**WEST SUSSEX COUNTY COUNCIL
STRATEGIC PLANNING CONSULTATION**

SUBJECT: EP/28/14/ - Drop kerb and parking to front.

2, Roundstone Drive, East Preston, West Sussex, BN16 1EP

2 Roundstone Drive, East Preston, Littlehampton, BN16 1EP

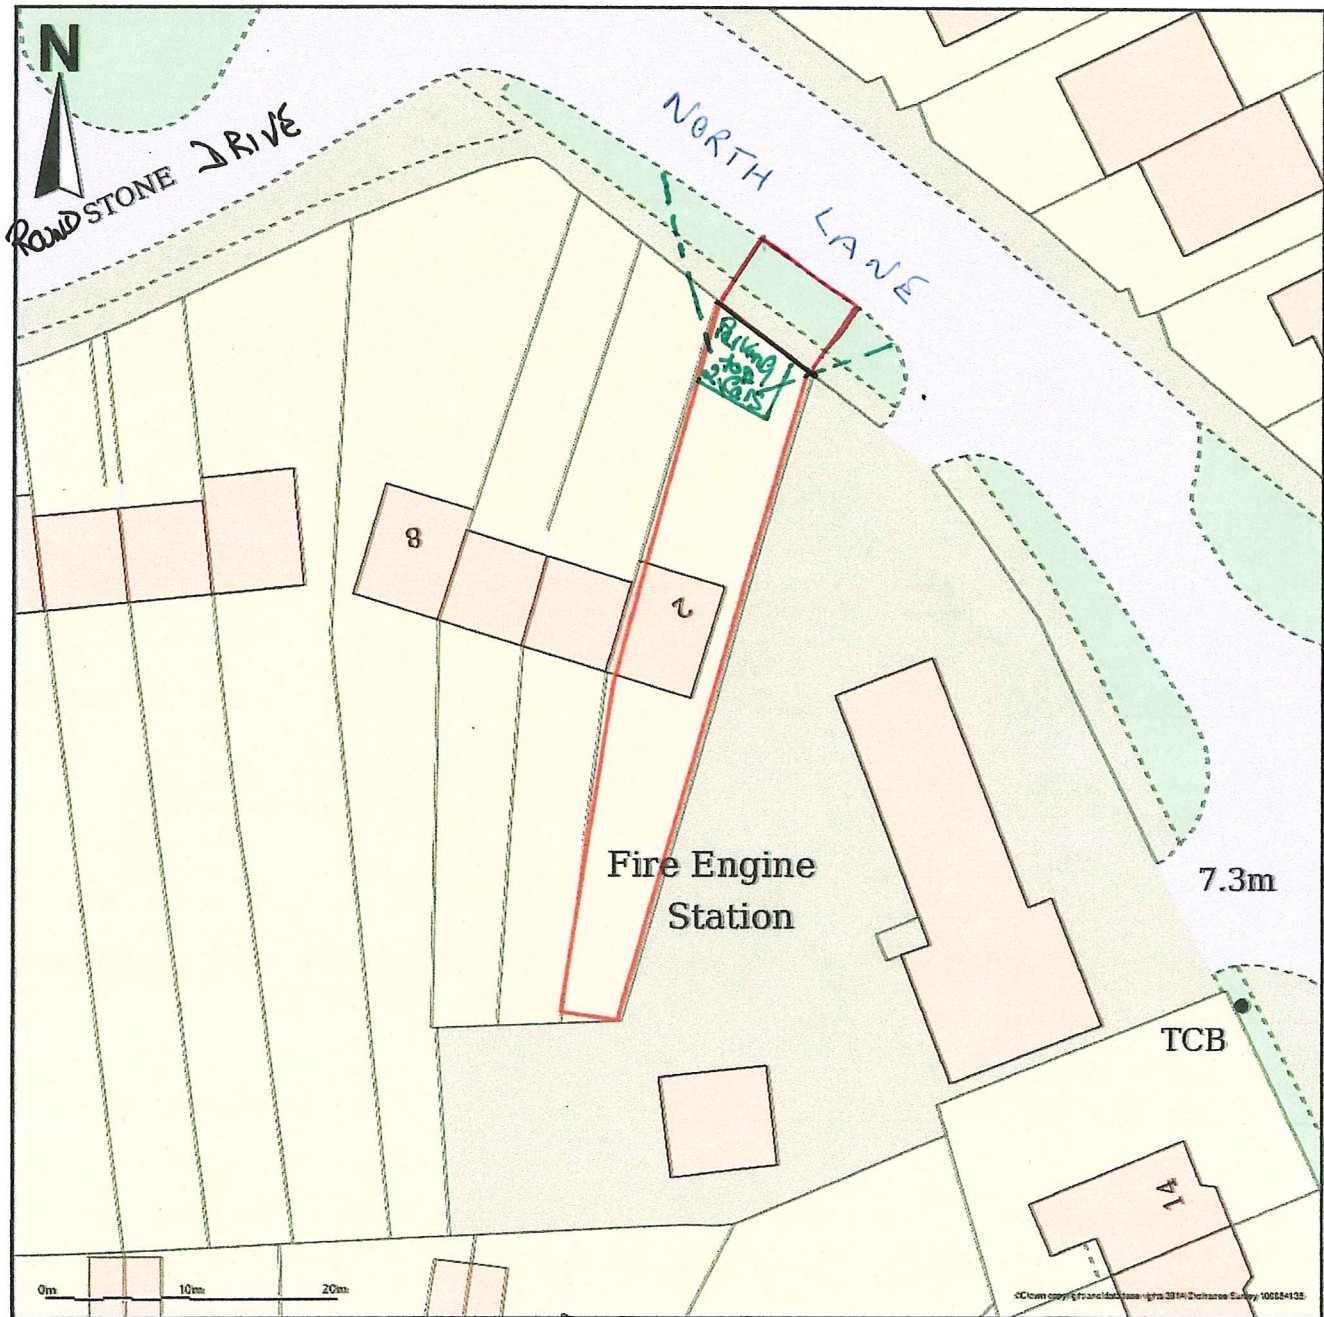
The proposal is for a new access and parking area onto North Lane. From an inspection of the plans alone, there is no apparent visibility issue at the point of access onto North Lane.

No part of the development shall be first occupied until visibility splays of 2.4 metres by 43 metres have been provided at the proposed site vehicular access onto North Lane in accordance with the approved planning drawings. Once provided the splays shall thereafter be maintained and kept free of all obstructions over a height of 0.6 metre above adjoining carriageway level or as otherwise agreed.
